Your Ref: OWPC20655
Our Ref: LU/255/18/HH 01-09-2018
Please ask for:
Zac Denton

Two storey side extension & single storey rear extension to provide garage, enlarged kitchen & dining room, additional bedroom & bathroom
64 Cornw all Road Littlehampton

Thank you for your internet representation made on 20th November 2018 which has been recorded as '**no objection**' with the comments as follows:

DRAWING TITLE
PROPOSED GROUND FLOOR PLAN
SCALE
1/50 at A3
REFERENCE
11805.05

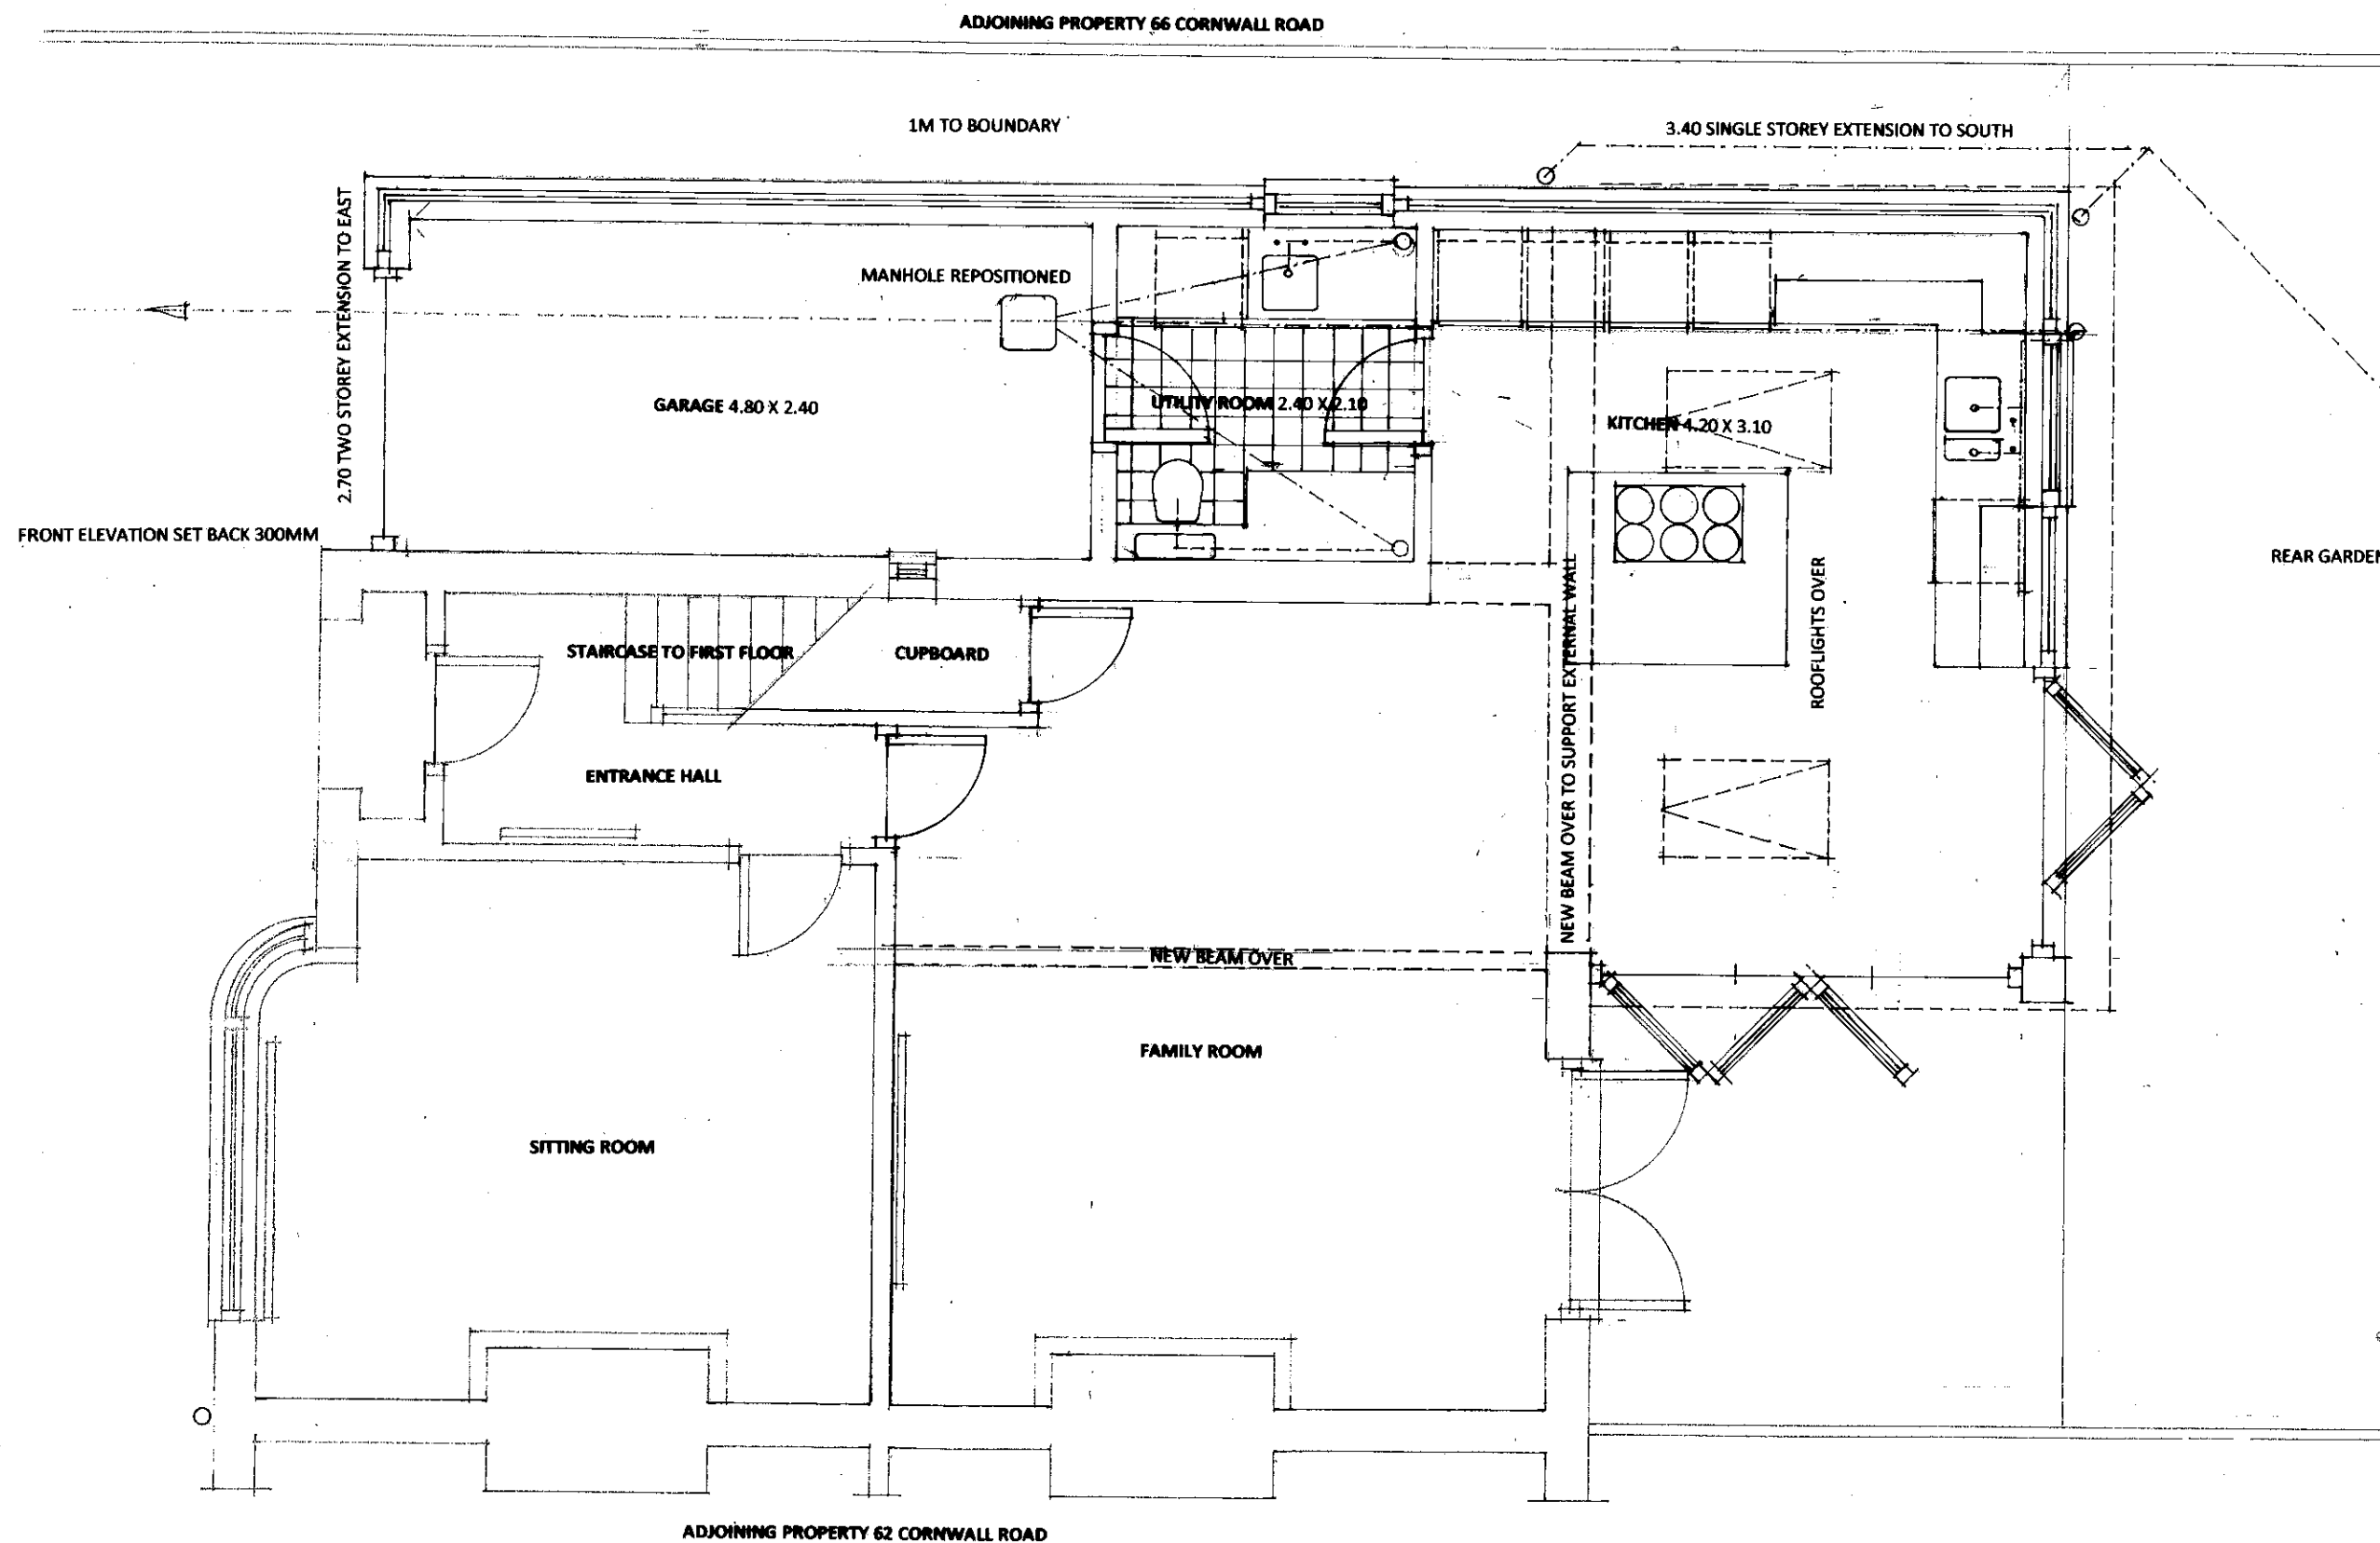
1. The proposed ground floor window on the east side of the extension will be very close to our property, and directly opposite a west facing window from our kitchen. Whilst our window is in an original part of our property and is therefore some distance from the boundary, the proposed window in the extension at no 64 will be very much closer. The applicant has discussed this with us, and indicated that the window will be of obscured glazing. They also agreed as part of their works to raise the fence height to full 1.8m height. We would like either or both of these (obscured glazing & 1.8m fencing) to be made a condition of the planning consent.

**EAST ELEVATION TO 66 CORNWALL RD**

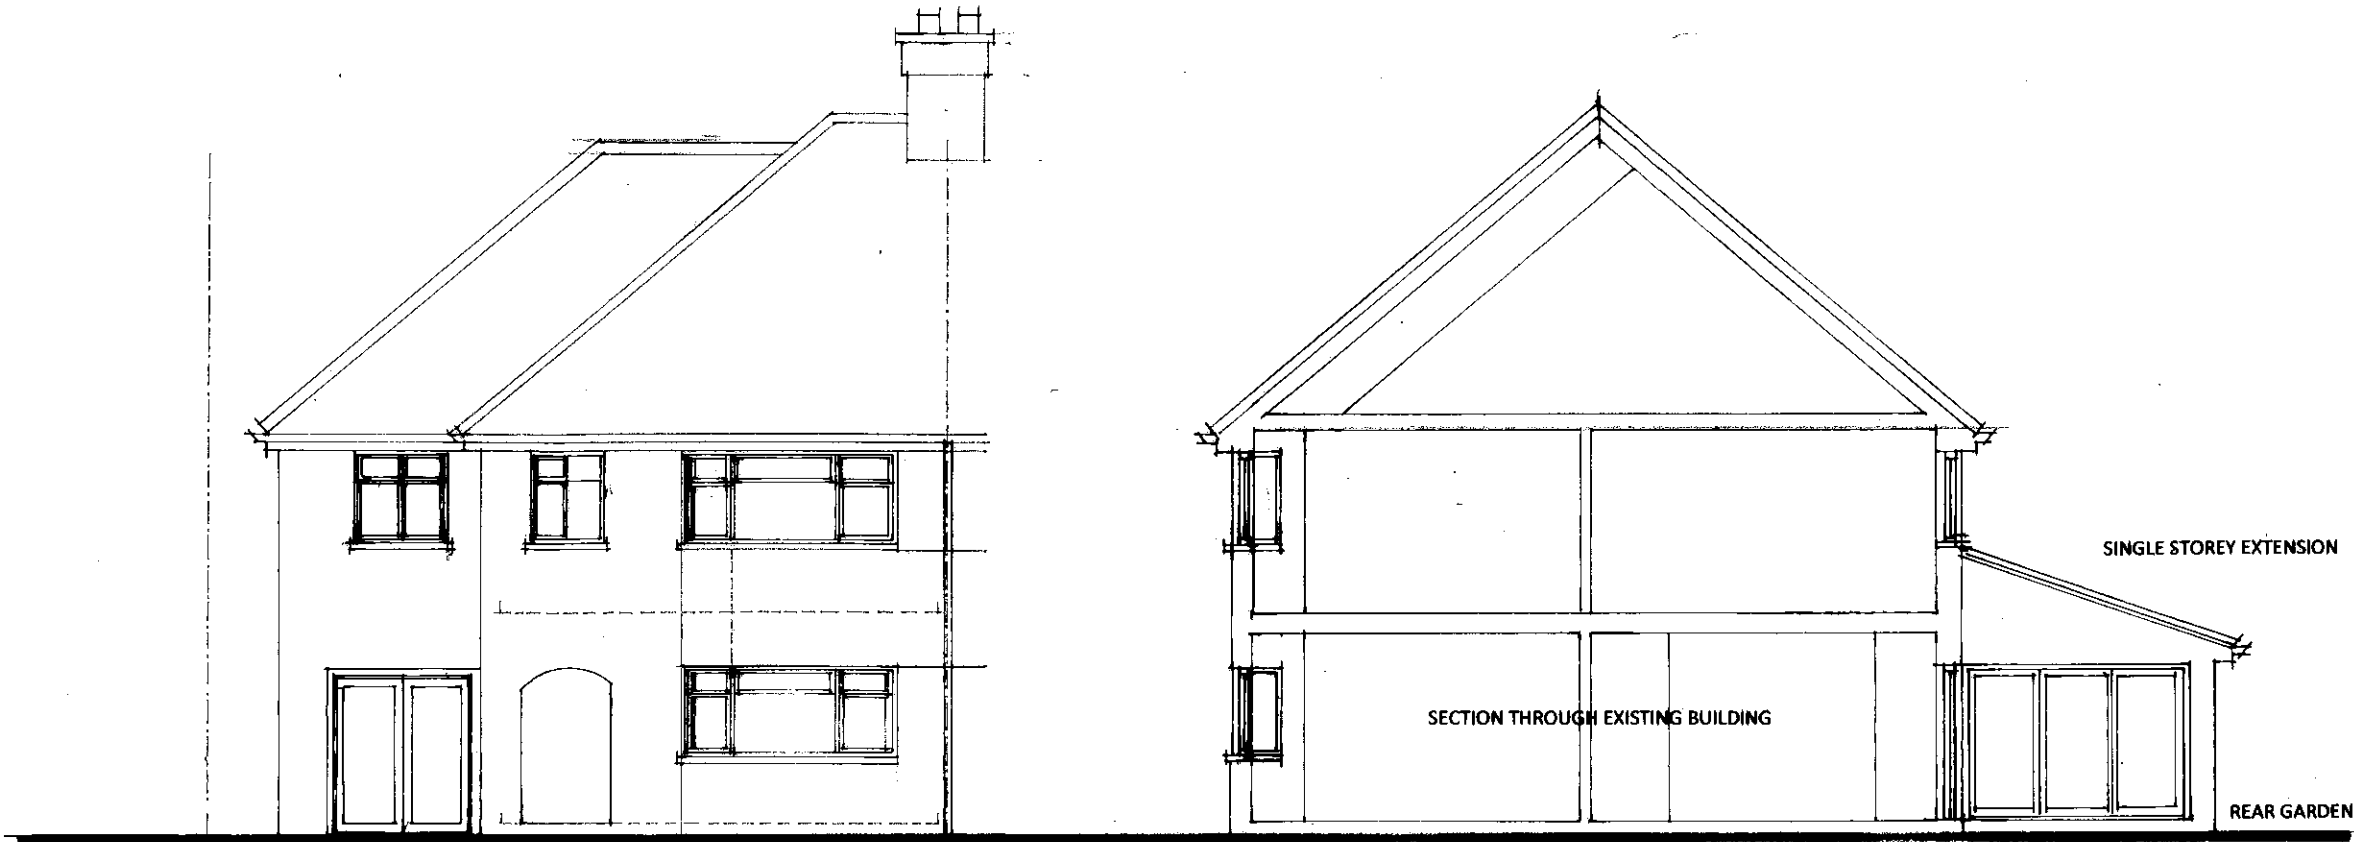
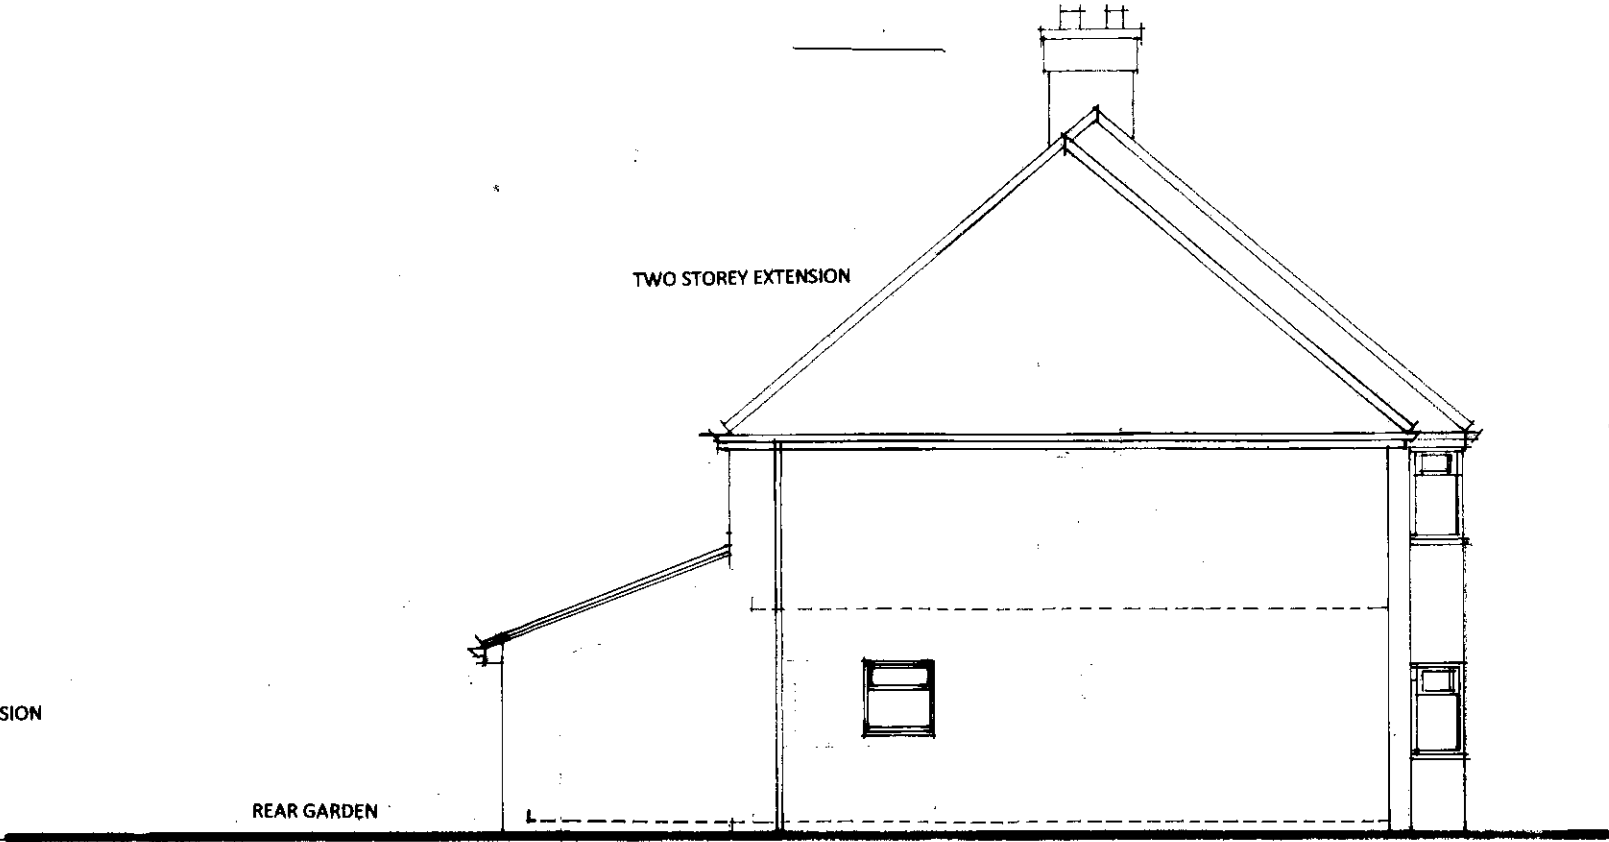
2. The proposed single story extension to the south, which is again much closer to the boundary than our own single story extension, will also project out further into the garden than our own (or the extension at no 62 which mirrors our own). That in itself is not an issue, but given the much closer proximity to the boundary, combined with the longer projection southwards, and combined with the extension having a single pitch roof, with a flat gabled wall, I think this will add to the perceived length when viewed from the ground floor of my property and may feel imposing. I would therefore ask that you consider stepping in the proposed single story extension along the east side, even if only by 300mm. This would "break up" what would otherwise be a very long flat and imposing wall. Additionally I would ask if the roof of the extension could be hipped to the east side away from our property. A hipped roof would also be in keeping with our own extension, and would therefore be more aesthetically pleasing as well as feeling less imposing when viewed from our property.
